*Planning Department
Transportation Development Services*

April 16, 2015

Re: Starbucks
4407 Lomas Blvd., NE
Traffic Circulation Layout
Engineer's/Architect's Stamp (NOT STAMPED) (J17-D012)

Based upon the information provided in your submittal received 4-13-15, the above referenced plan cannot be approved for Building Permit until the following comments are addressed:

SITE PLAN FOR BUILDING PERMIT

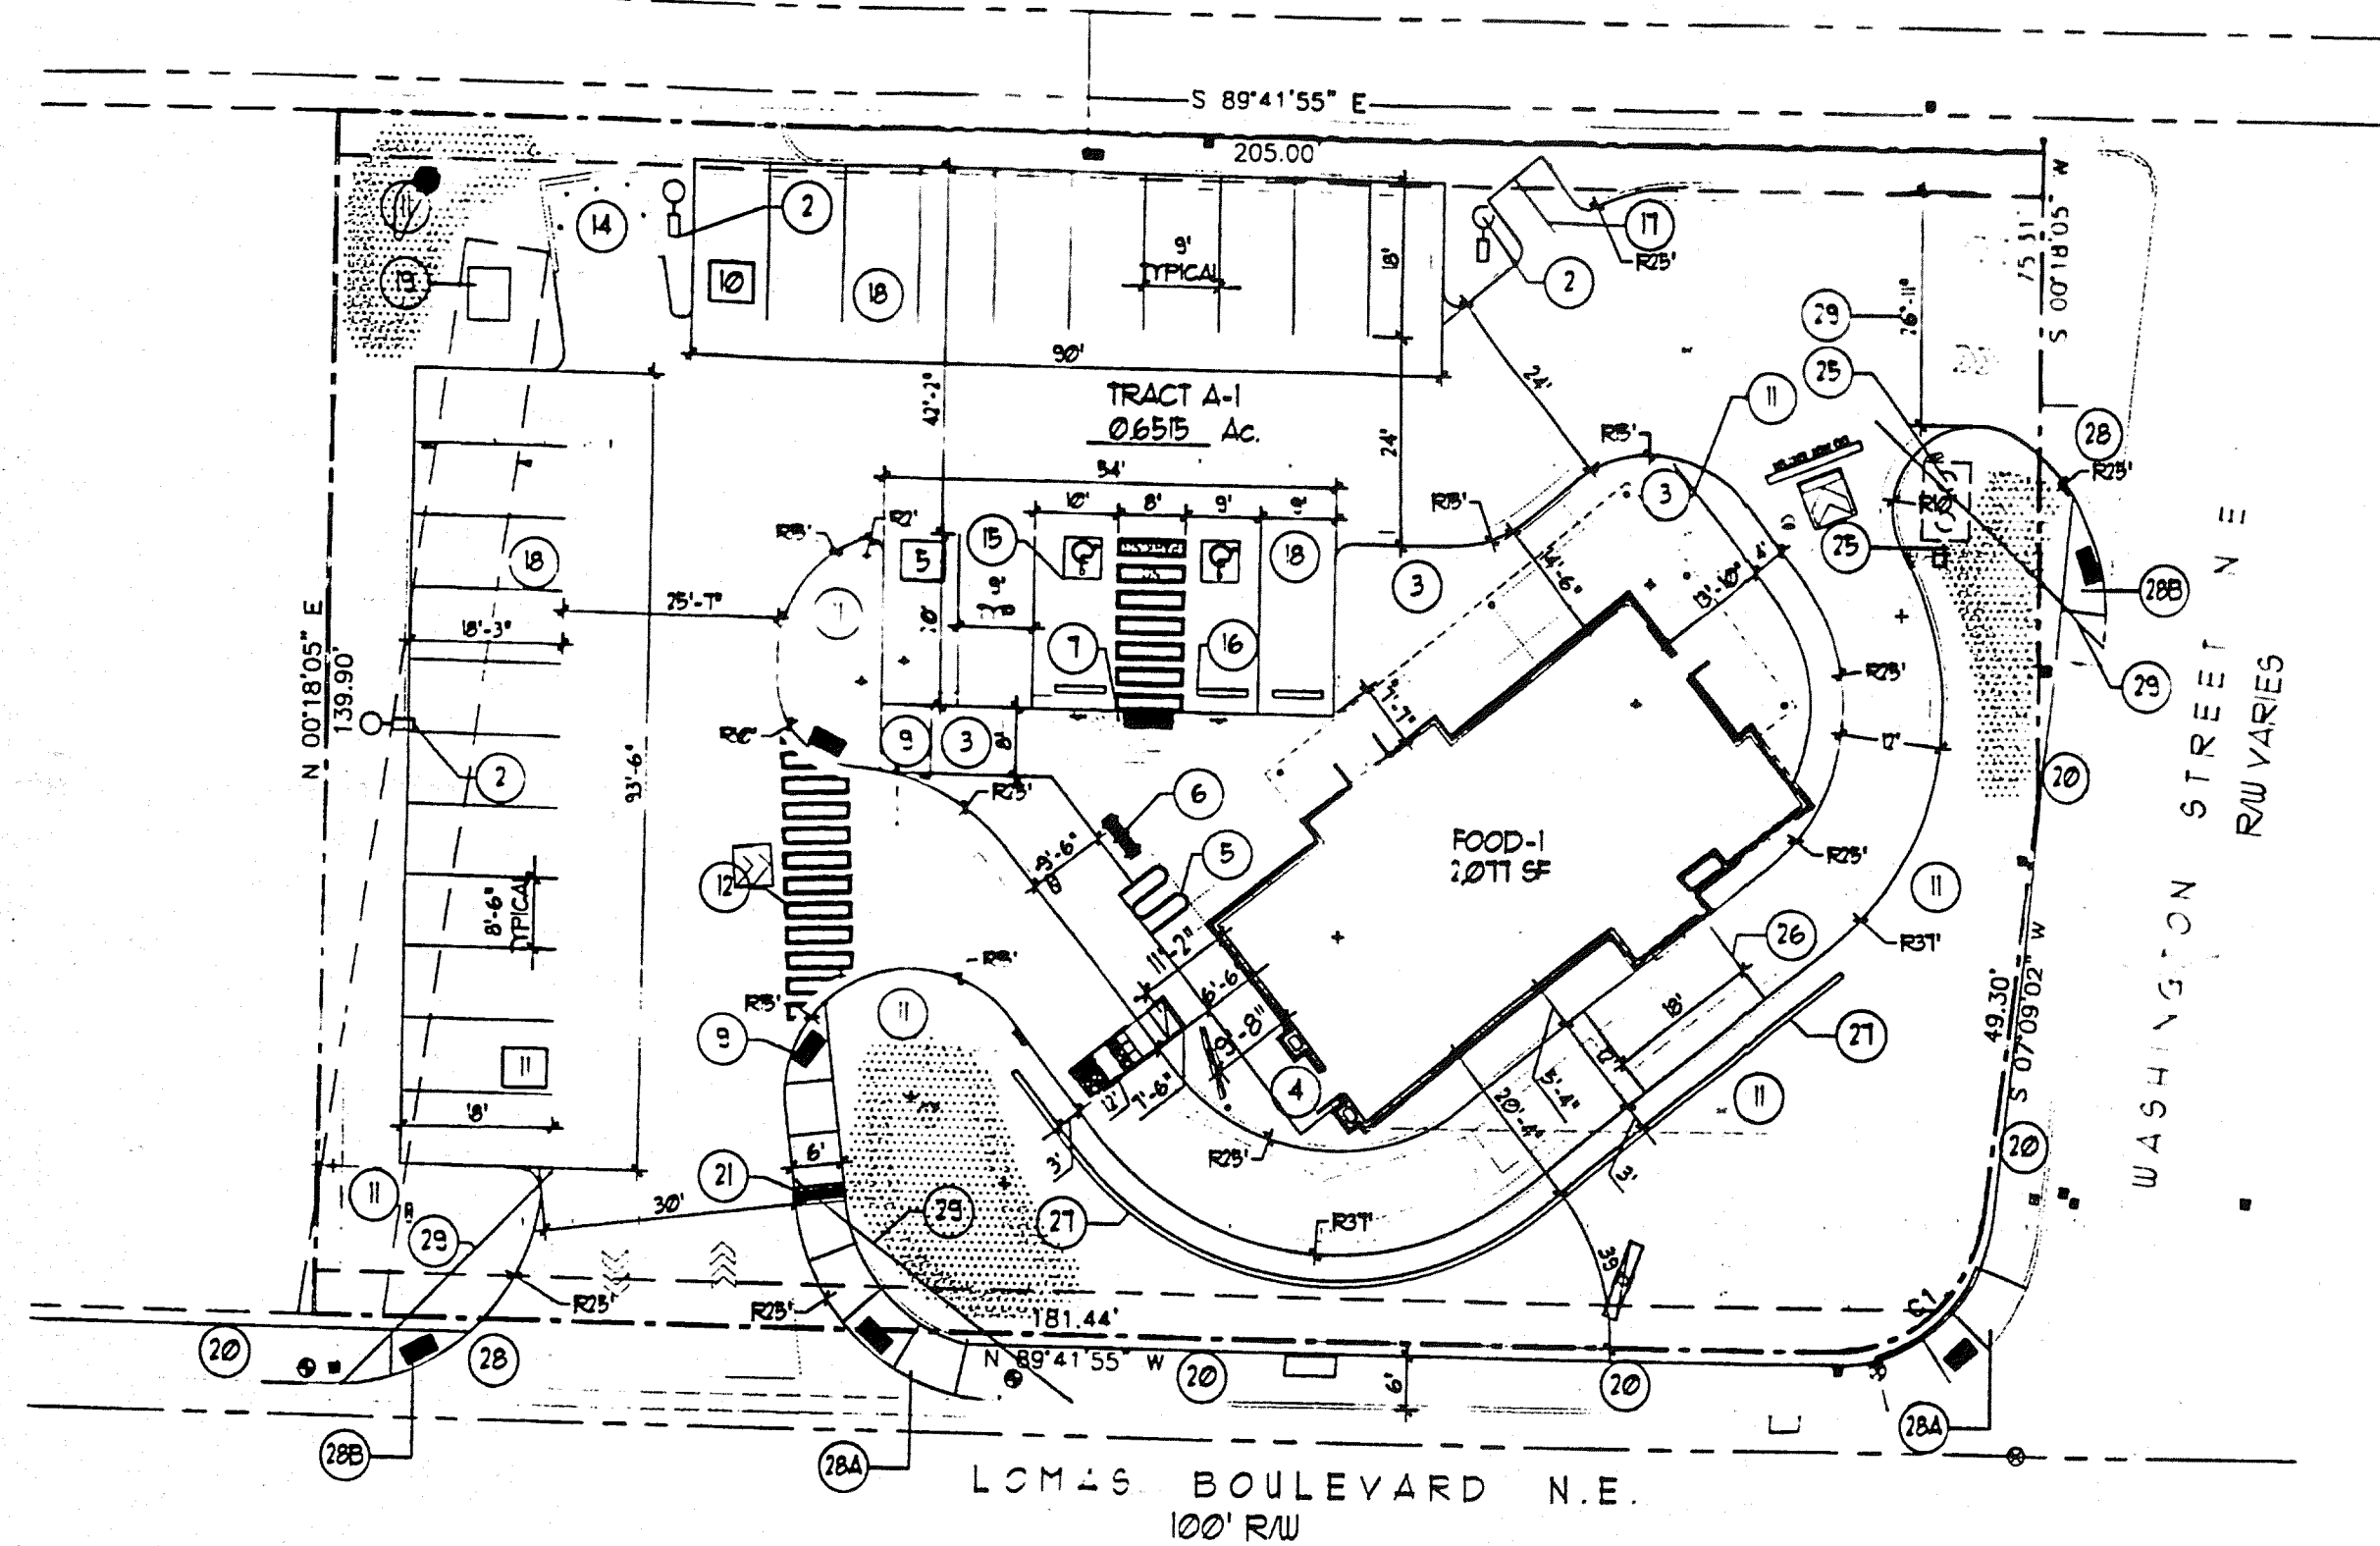
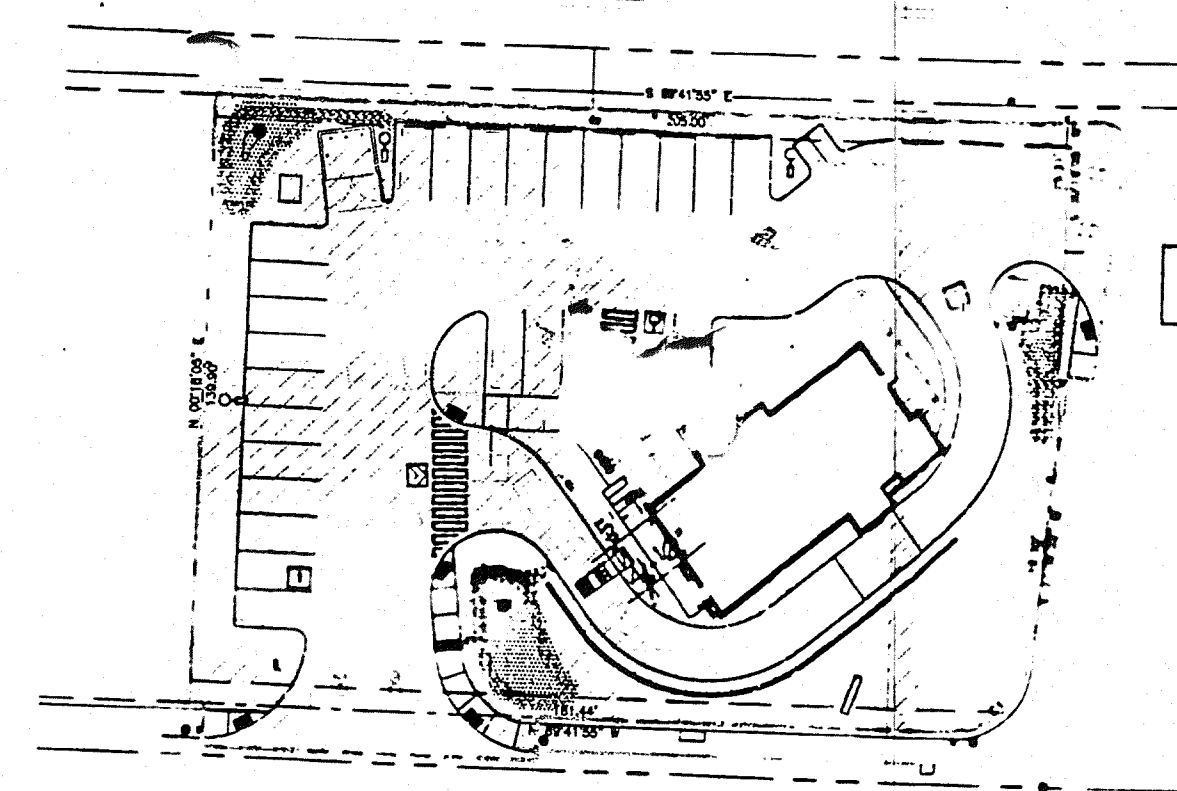
1. Clarify the extents of the current phase.
2. The traffic circulation layout must be stamped, signed, and dated by an engineer or architect licensed in the state of New Mexico.

3. Per the Development Process Manual, Chapter 27 Drafting Standards, "Standard sheets must be 24" by 36" having a margin of 2" along the left and 1" on the top and bottom."

4. Please dimension the existing sidewalk and label existing ADA approved ramps to existing sidewalks.
5. Please list the width and length for all parking spaces.

6. Please provide detail of proposed new drive pad entrances on Lomas Blvd. and Washington St. and call out CAO standard drawing numbers.
7. The ADA van accessible sign must have the required language per 66-7-352.4C NMSA 1978 "**Violators Are Subject to a Fine and/or Towing.**"

8. Show all drive aisle widths and radii.
9. Per the DPM, a 6 ft. wide ADA accessible pedestrian pathway is required from the HC parking stall access aisles to the building entrances. Please clearly dimension ADA pathway and building entrances on the drawing.

10. Design delivery vehicle route needs to be shown.

11. Service vehicle and/or refuse vehicle maneuvering must be contained on-site; provide a copy of refuse approval (if applicable).
12. One-way vehicular paths require pavement directional signage and a posted "Do Not Enter" sign at the point of egress. A detail was given, but not shown on drawing. Please clearly show detail on points of egress.
13. It is not apparent what type of pavement surface is being proposed. Please label type of proposed pavement surface.
14. Please add the following note to the clear sight triangle: "Landscaping and signage will not interfere with clear sight requirements. Therefore, signs, walls, trees, and shrubbery between 3 and 8 feet tall (as measured from the gutter pan) will not be acceptable in this area."

15. Please add "Clear Sight Triangle" detail to drive pad entrances on Lomas Blvd. and Washington St.
16. Work within the public right of way requires a work order with DRC approved plans.
17. Please include two copies of the traffic circulation layout at the next submittal.
